**From:** Joe Gilbert  
**Sent:** Wednesday, October 17, 2012 2:01 PM  
**To:** Jeff Watson  
**Subject:** RE: BLAs for comment

I asked a question of you last week.... Regarding Knowles BLA

[BL-12-00024 Panattoni](#)  
[BL-12-00015 Knowles](#)

**Survey for  
Boundary Line Adjustment**

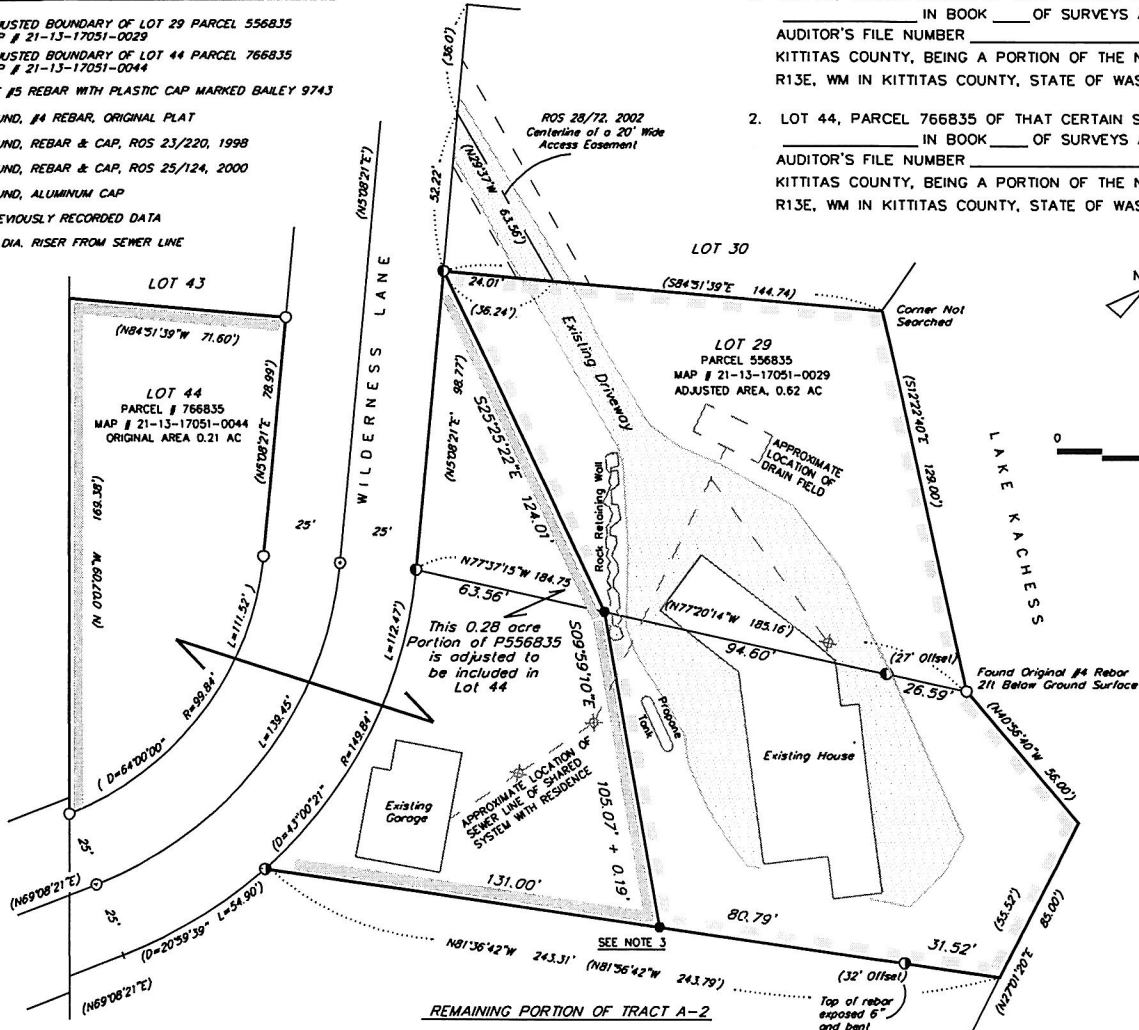
Sorry, guess I missed the question part... I don't normally assess the proposal til' comments are all in... Personally I don't get too upset about parcels crossing roads etc. I will condition no intervening ownership. Dan didn't like 'em, I have not addressed the issue with Doc yet.

I did a site eval up there last month, and it is determined that a primary and reserve area will fit within the property across the road. Depending on what the septic system that is shared between the two buildings shakes out, they would need an easement if they keep the system as is. Other than that it is community water, I see no other EH issues.
